PEERLESS FARMS
PRELIMINARY PLAN
16975 FALCON HIGHWAY, PEYTON, CO

EPC STORMWATER REVIEW COMMENTS ARE
SHOWN IN ORANGE BOXES WITH BLACK TEXT

PEERLESS FARMS PRELIMINARY PLAN - COUNTY FILE NO. XXXXXX

1 ALTERNATIVE HAMMERHEAD/PRIVATE FENCE LAYOUT DETAIL
TYPICAL TURN ROUND

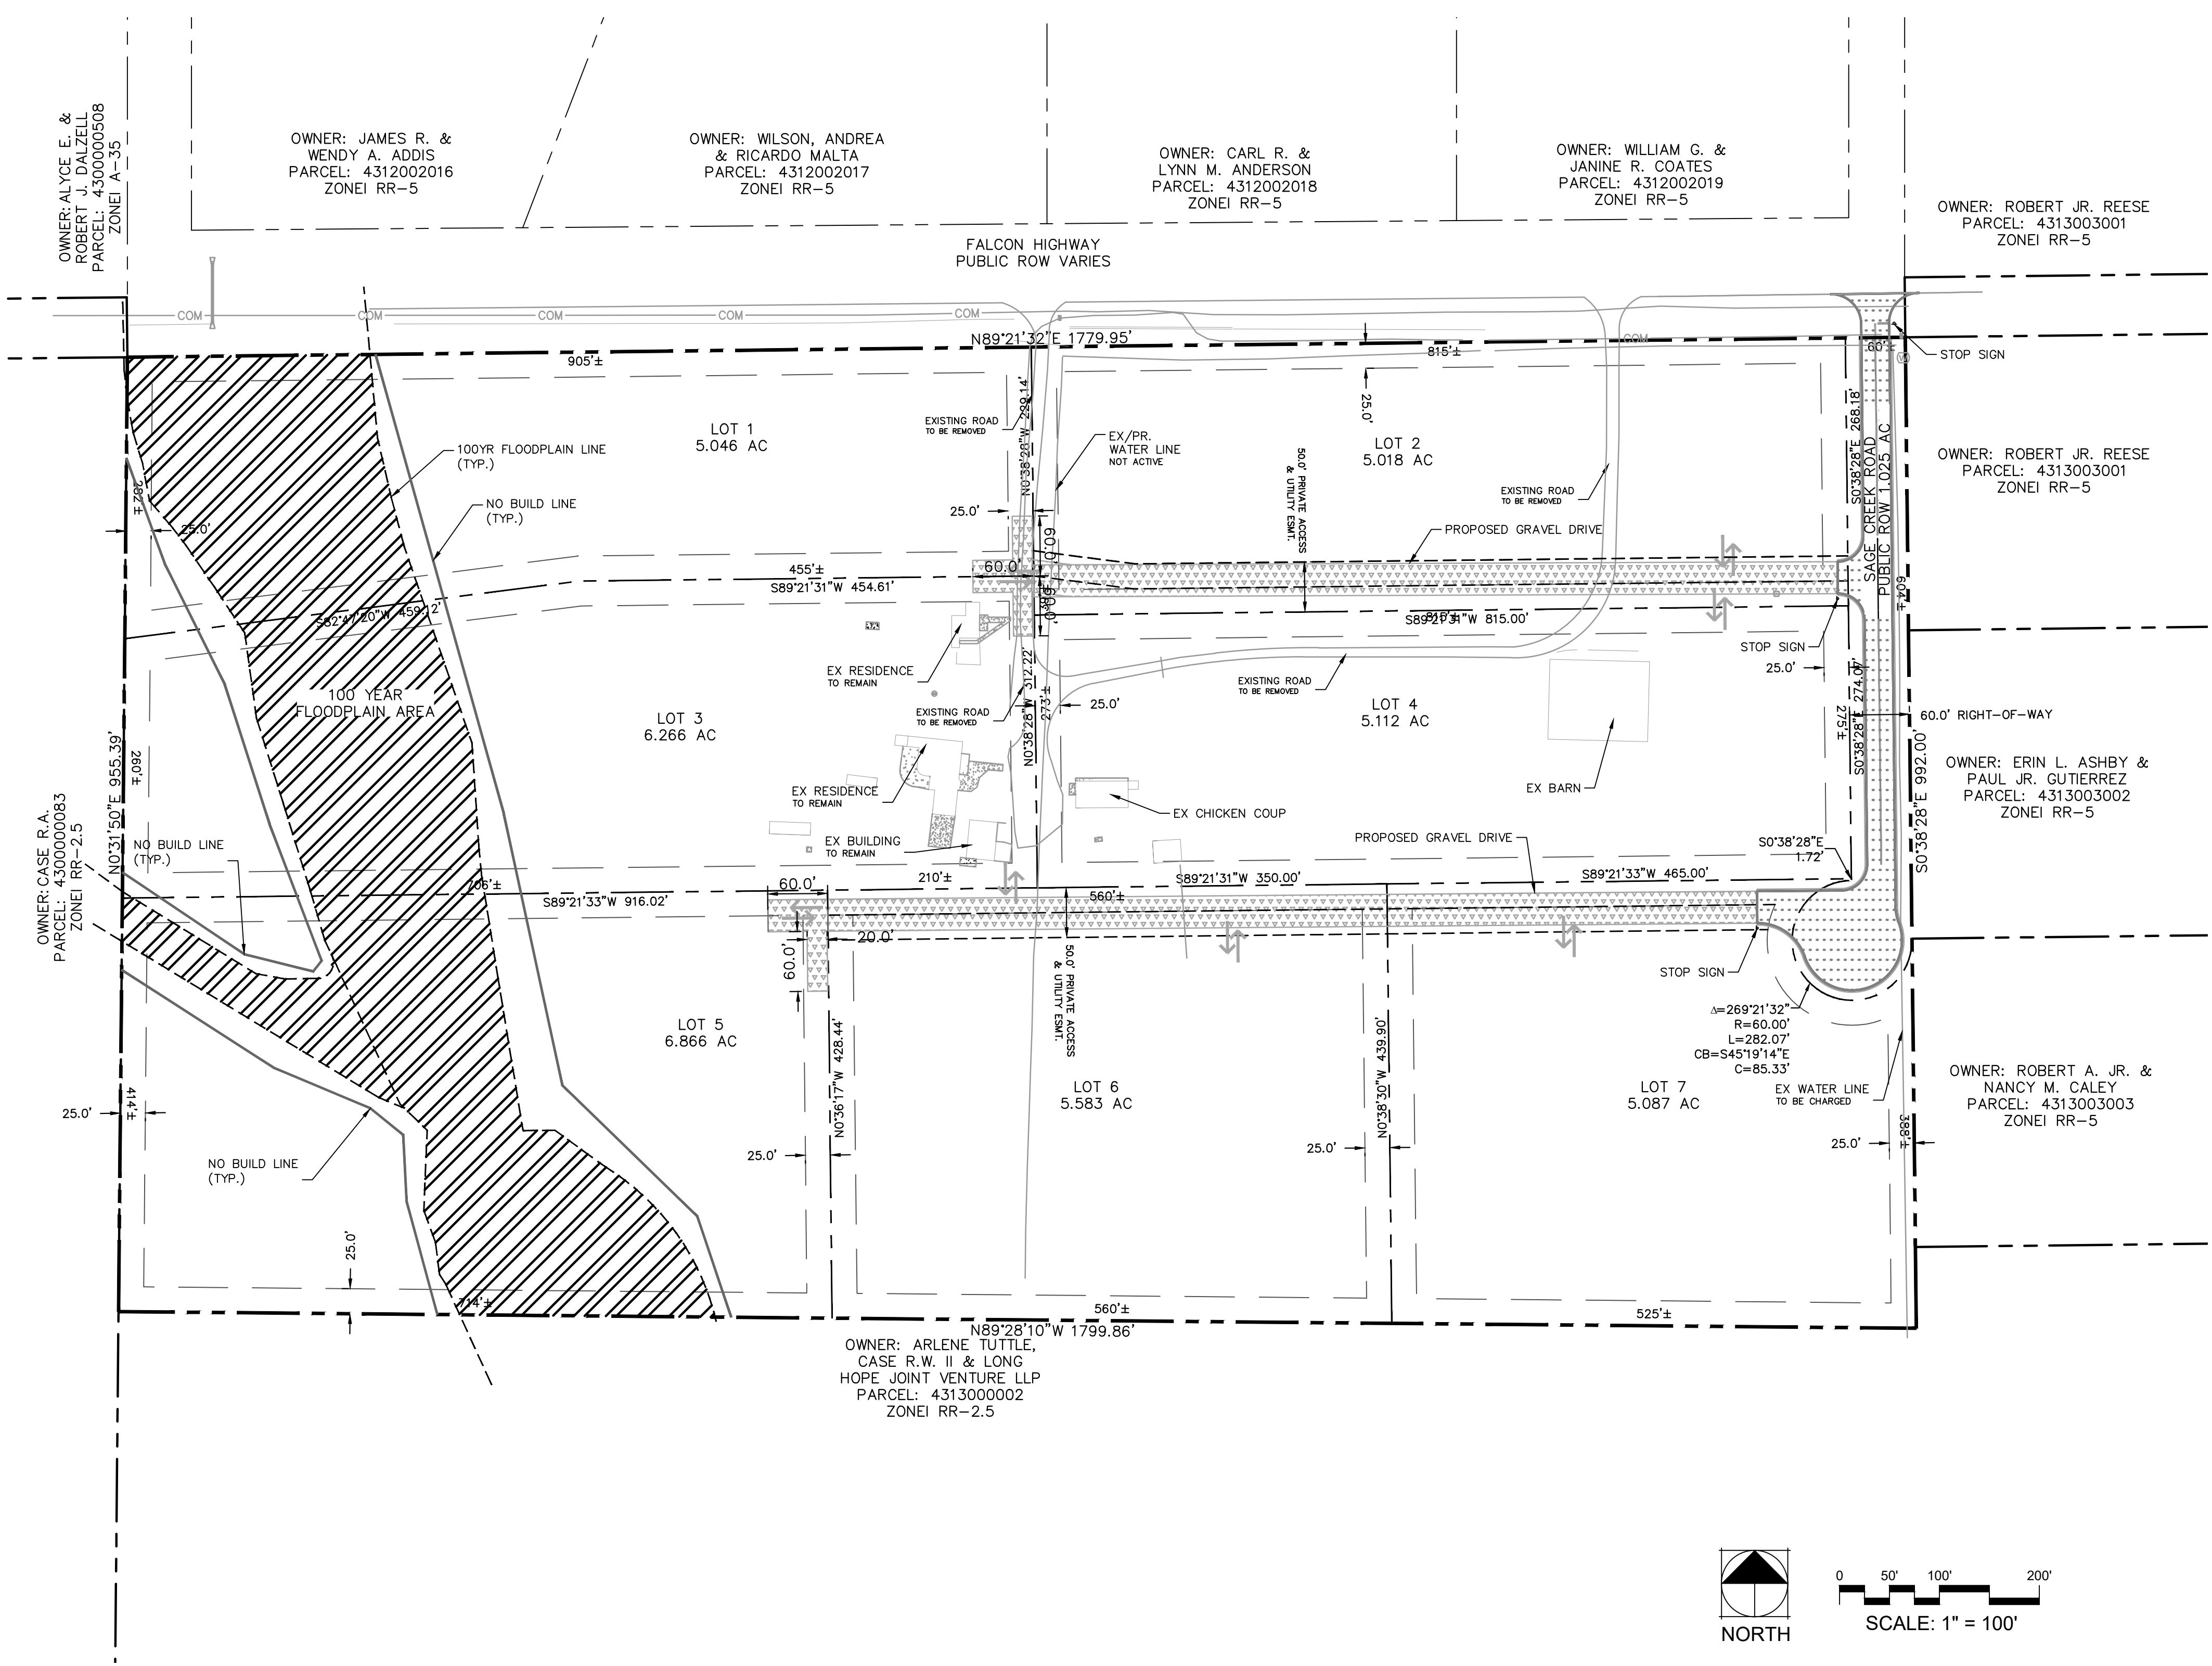
Property is within a FEMA
Floodplain. Please revise note.

Include street section

Add the following note: Unless otherwise indicated, all side, front, and rear lot lines are hereby platted on either side with a 10 foot (use 5 feet for lots smaller than 2.5 acres) public utility and drainage easement unless otherwise indicated. All exterior subdivision boundaries are hereby platted with a 20 foot (use 7 feet for lots smaller than 2.5 acres) public utility and drainage easement. The sole responsibility for maintenance of these easements is hereby vested with the individual property owners.

Who will maintain the private driveways? Include a note explaining.

Rephrase:
There shall be no direct lot access to Falcon Highway.

Show information, constraints & features
from Figure 11 in the Soils & Geology
report on this sheet.

Include linetypes used in the legend.
